Consultation Response from: KC Environmental Health (Pollution & Noise Control)
2026/91956 - The Haven, 15, Shelley Woodhouse Lane, Shelley, Huddersfield, HD8 8NB
Discharge of details reserved by conditions 15 (Preliminary Risk Assessment), 16 (Remediation Strategy), 17 (Phase II Intrusive Site Investigation Report), 18 (Verification Report) on previous permission 2025/92184 for outline application for erection of residential development (one dwelling)
Date Responded:
13th October 2026

Responding Ref:
WK/202623368

Condition 15 - Phase II Intrusive Site Investigation Report

Site Investigation Plan
4276 Shelley Woodhouse Lane,
Huddersfield

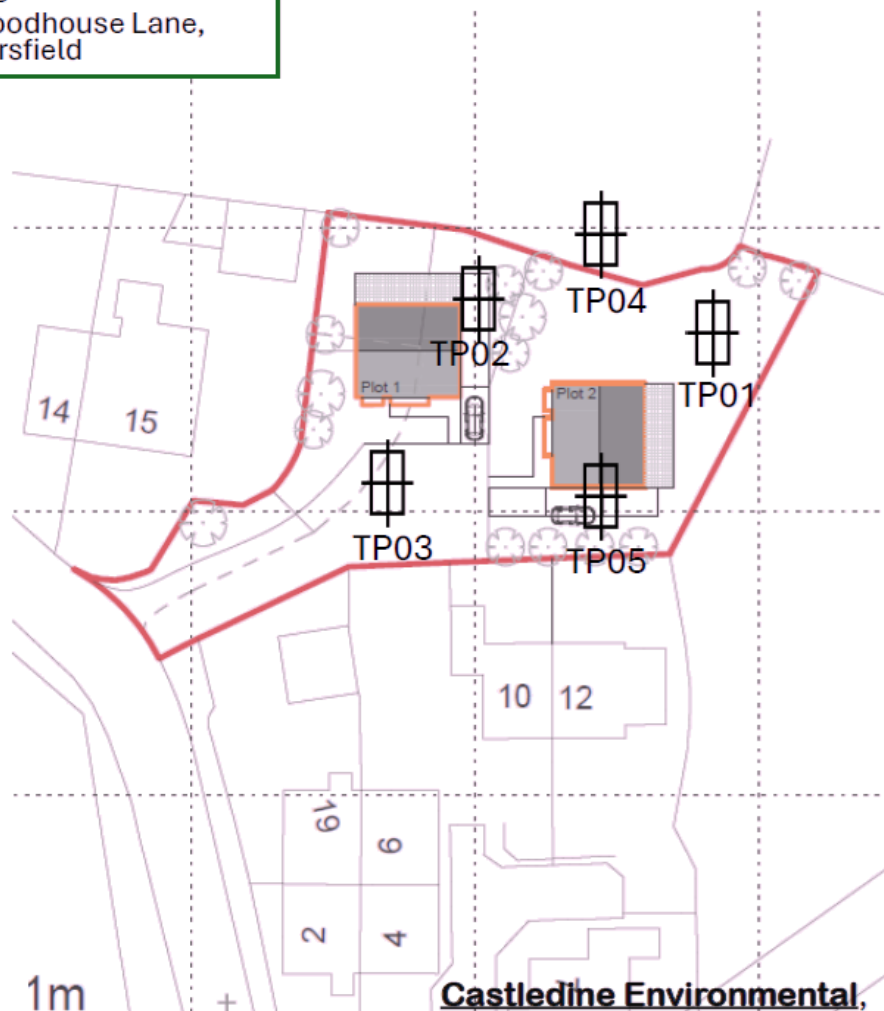
Furthermore, the submitted report appears to pre-date changes to the proposed development and therefore may not be representative of the current scheme. This further undermines confidence that the investigation has adequately assessed all pollutant linkages relevant to the development now proposed.
